From: Amanda Scholes on behalf of Planning.Responses
Sent: 09 November 2017 08:54
To: Planning Scanning
Subject: FW: Planning Consultation on: AL/102/17/RES

Additional greenspace comments. Please upload to the website.

From: Sue Howell
Sent: 08 November 2017 16:44
To: David Innes
Subject: RE: Planning Consultation on: AL/102/17/RES

Drawing Number 102 Rev A

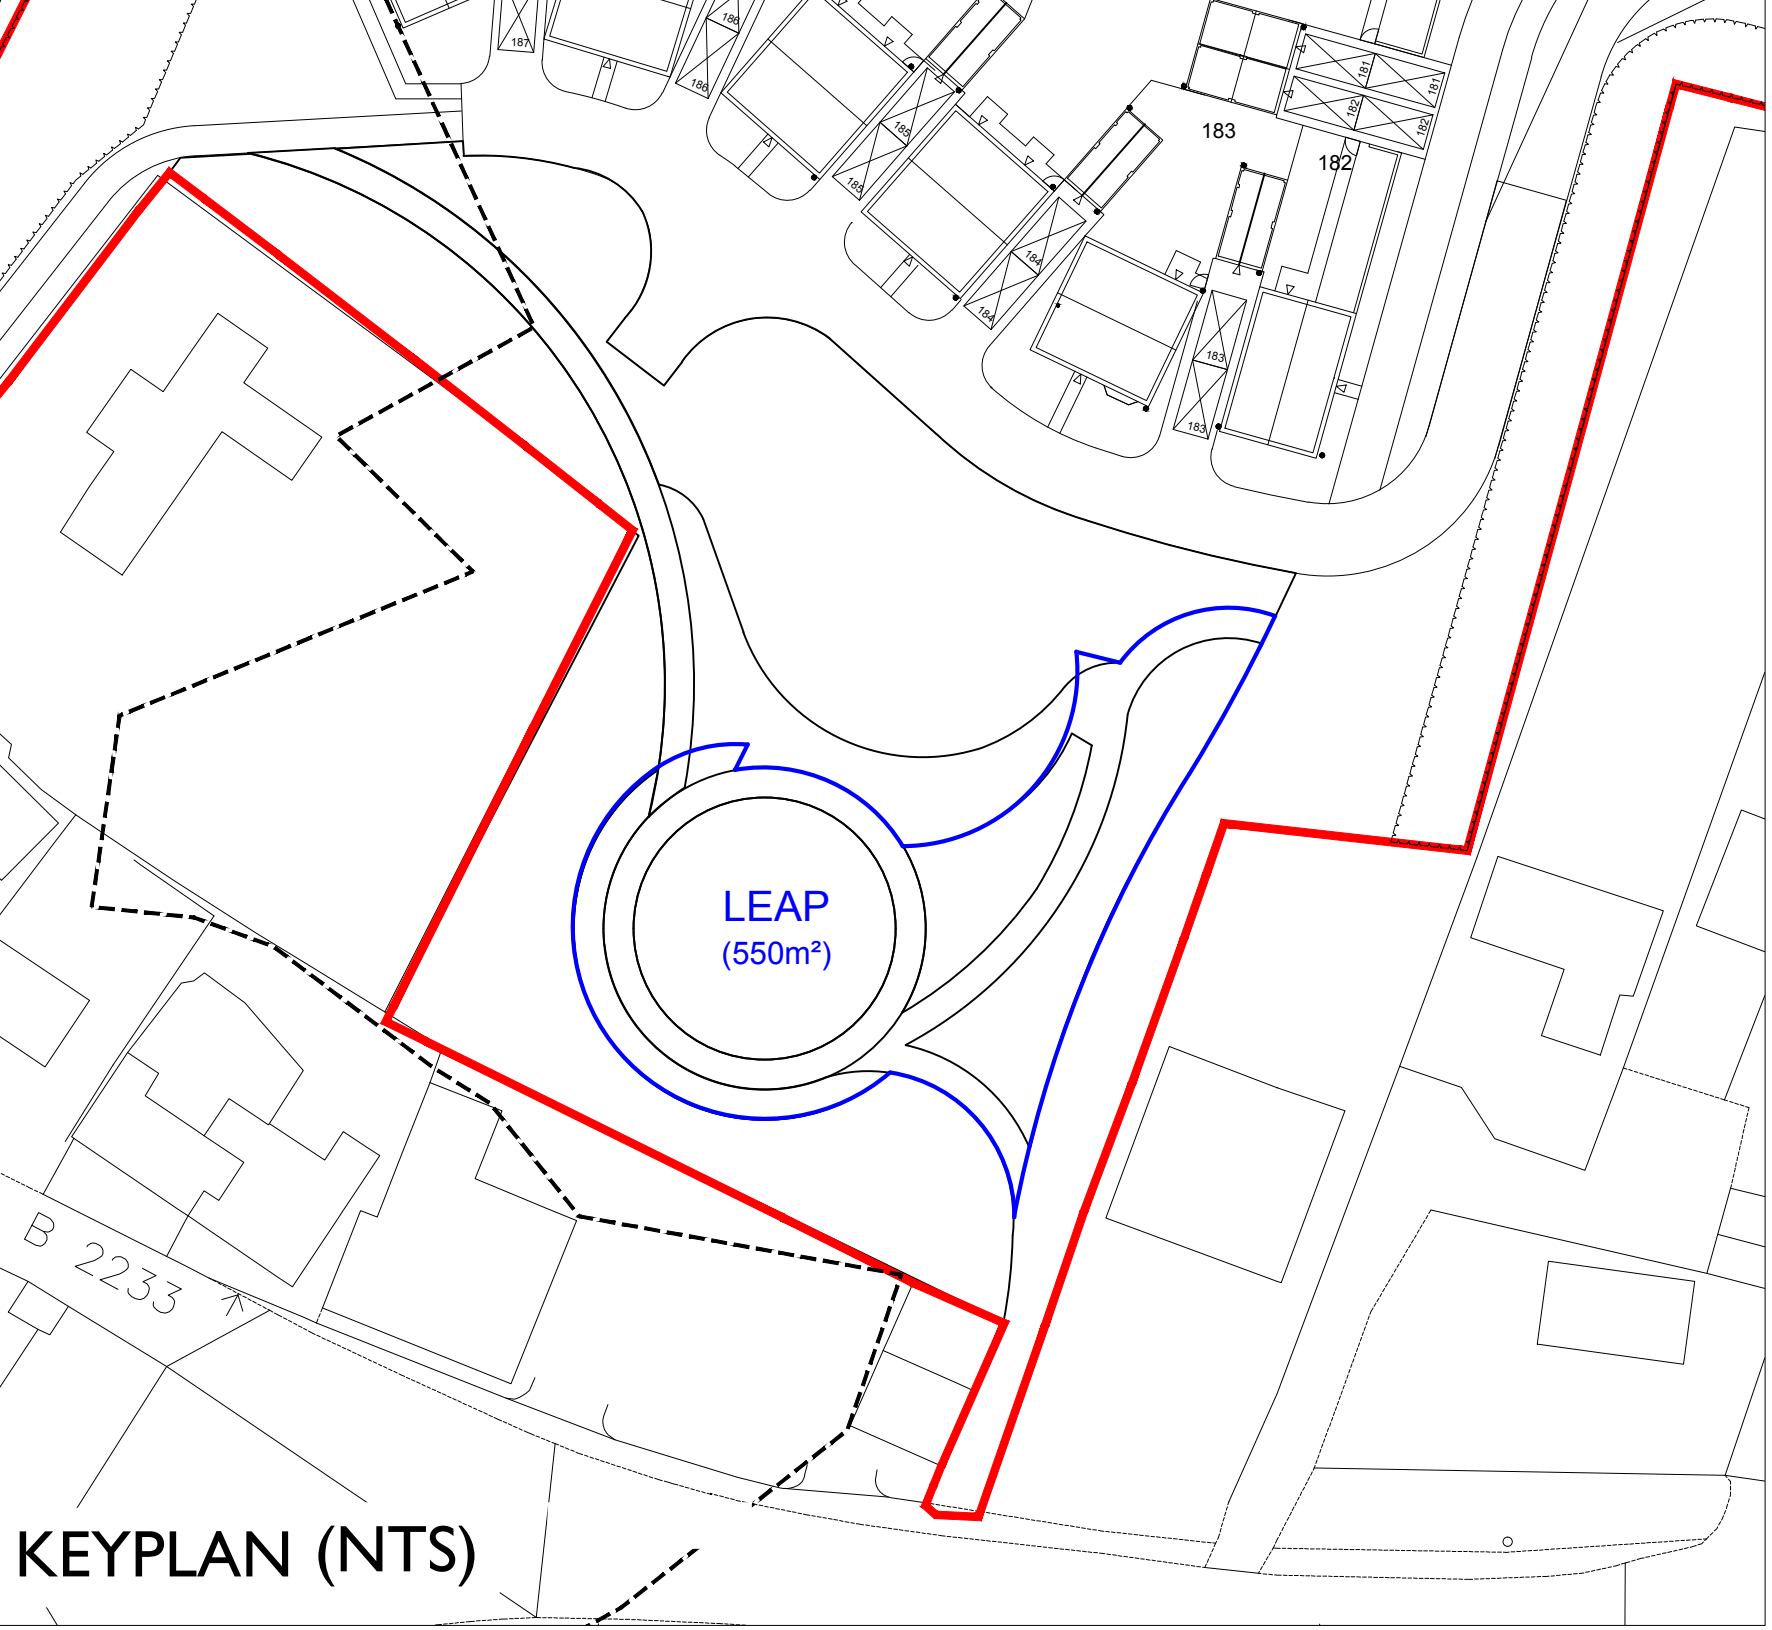
Have just had a quick look over the addition re southern LEAP which you/resident has queried. I am not able to scale from the drawing I have as only have access to portal plans which don't print to scale. The Leap is quite close to existing property to the east, probably no closer than to Apogee House to the south/west of the proposed LEAP the only difference being that Apogee House has some existing tree cover between. You may be able to scale the distance, but I think about borderline ok.

The main issue here is that the LEAP drawing Southern Leap Plan dwg 102 rev A shows a semi mature tree proposed to be planted into the planting bed between the existing dwelling (to the east) you mention and the play area, however on re-examining the Supplementary 20/09/17 proposed soft landscape 3 of 4 JSL 2869 503 rev B this tree has been omitted. It would be prudent in this case I think to ask that the developer to amend this drawing to include this tree as mitigation/screening for siting of play area in this location.
